ENTECH
ENGINEERING, INC.

**SOIL, GEOLOGY, AND GEOLOGIC HAZARD STUDY
WINSOME SUBDIVISION – FILING NO. 2
A PORTION OF PARCEL NO. 51000-00-493
17480 MERIDIAN ROAD NORTH
EL PASO COUNTY, COLORADO**

January 26, 2021

- BOUNDARY LINE
- EASEMENT LINE
- PRESERVATION LINE
- WETLAND DELINEATION
- APPROXIMATE FEMA FLOODPLAIN
- DRAINAGE EASEMENT
- ADDRESS
- RADIAL BEARINGS

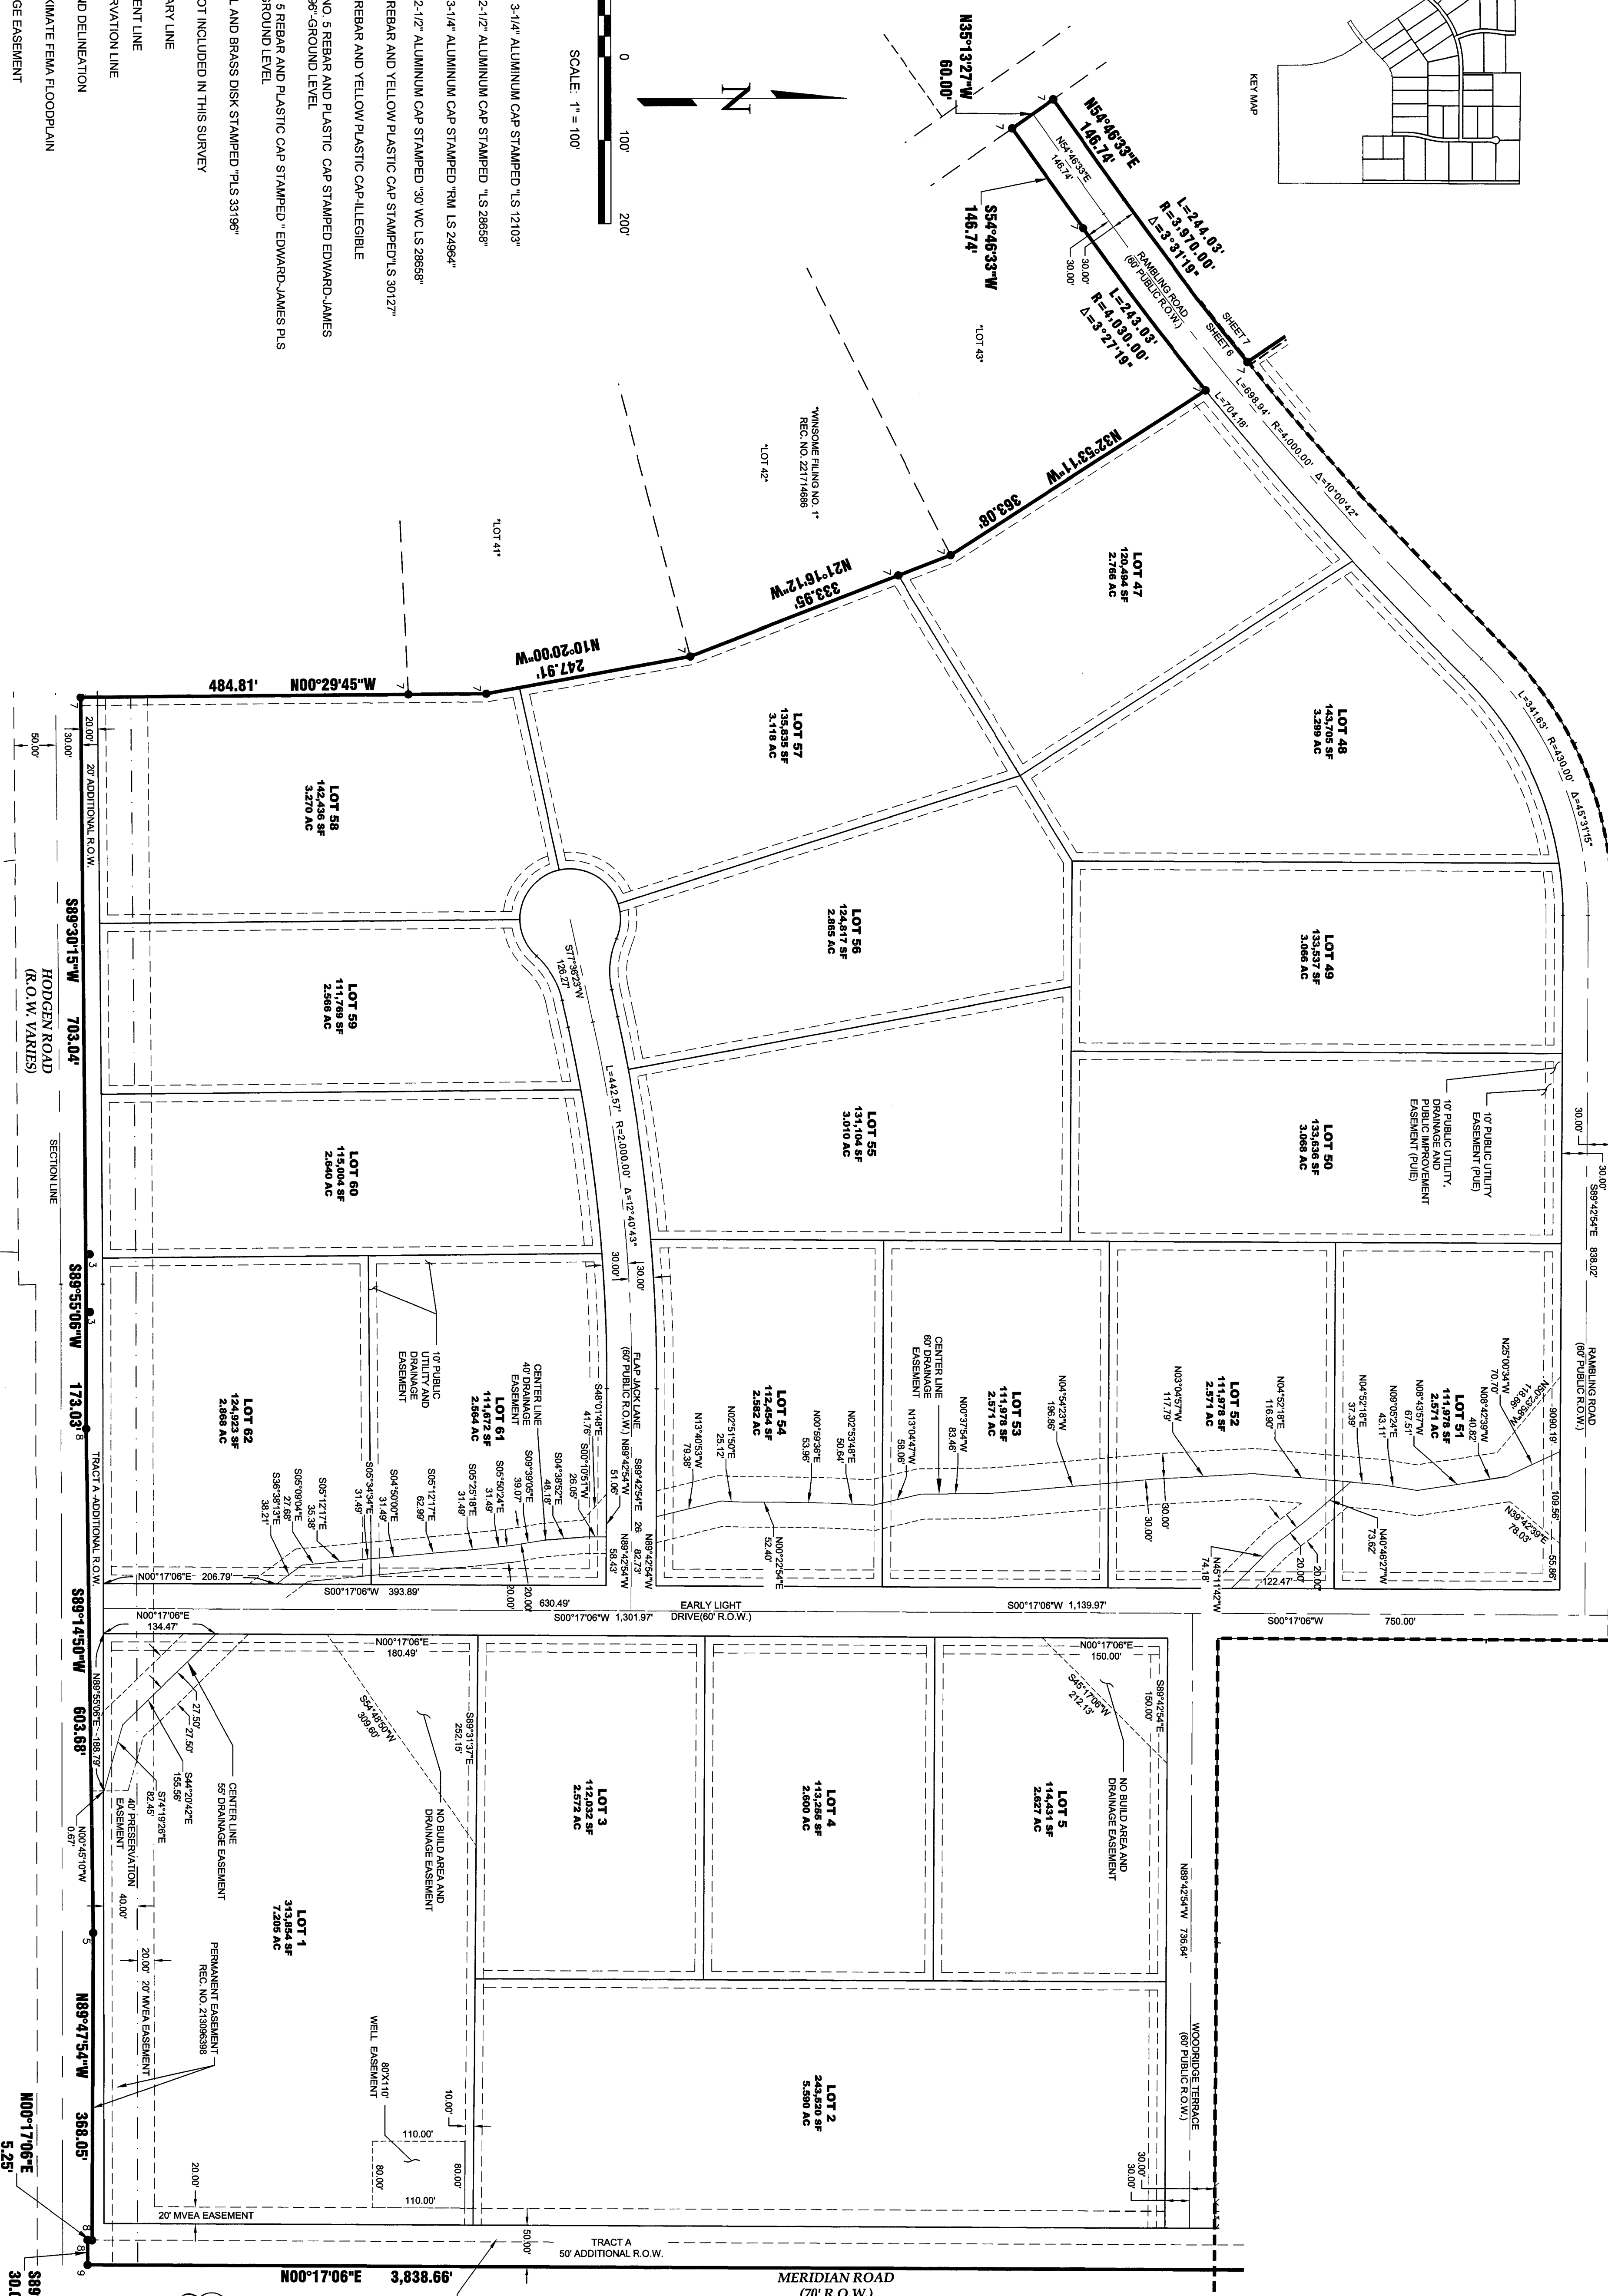
Add as plat note

Show all areas as of seasonal groundwater as
no-build on plat.
